Our Case Number: ACP-323980-25

Re: Proposed Water Supply Project for the Eastern and Midlands Region
in the counties of Clare, Limerick, Tipperary, Offaly, Kildare, and Dublin.

Planning Authority report in accordance with the requirements of
Section 37E (4) of the Planning and Development Act 2000 (as amended).

An Coimisiún Pleanála Ref. No.	323980-25
Applicant	Uisce Éireann
Project	Water Supply Project for the Eastern and Midlands Region in the counties of Clare, Limerick, Tipperary, Offaly, Kildare and Dublin.
Site Location	Ticknevin, Kilpatrick, Ballybrack, Drummond, Kilkeaskin, Ballynakill Lower, Parsonstown, Loughnacush, Drehid, Timahoe West, Timahoe East, Coologmartin, Derryvarroge, Derrycrib, Newtownmoneenluggagh, Fanaghs, Cooltrim South, Donadea, Aghafullim, Clonshanbo, Belgard, Farranadum, Baltracey, Raheen, Barreen, Graiguesallagh, Johninstown, Baybush, Newtownmacabe, Barberstown Upper, Barberstown, Barberstown Lower, Cast ledillon Upper, Ardrass Upper, Reeves, Friarstown, Commons Upper, Kearneystown Upper, Dangan and Kearneystown Lower, Co. Kildare

Drawing file: Chapter 7 Traffic & Transport / Figure-7.2-7.8-Haul-Roads-(with-access-points).pdf

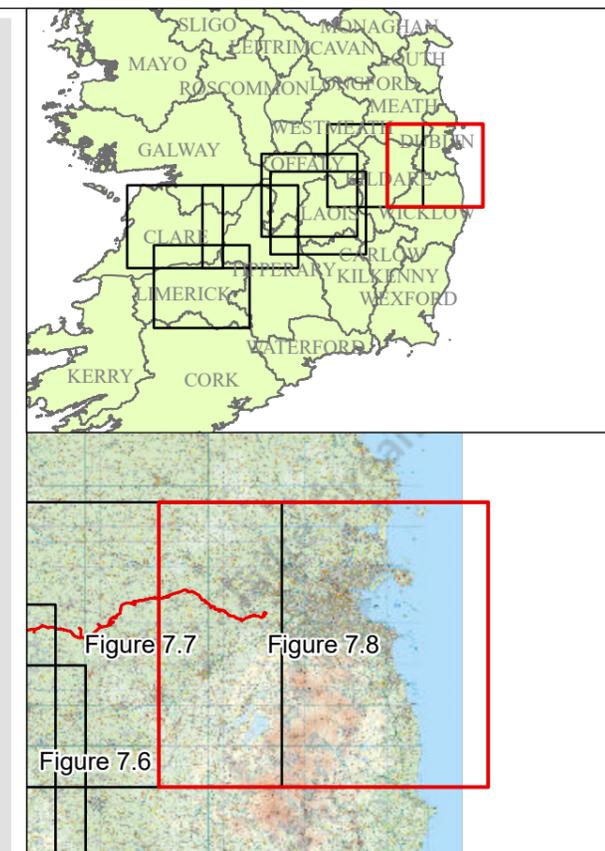
EIAR – Volume 5 Chapter 7 Figure 7.2-7.8 outlines the haul routes with access points. This drawing is not detailed enough for KCC. Each access point will require a specific drawing showing sightlines and swept path analysis.

1. Submit a review of all haul routes in Kildare County Council including the requirement for installation of passing bays.
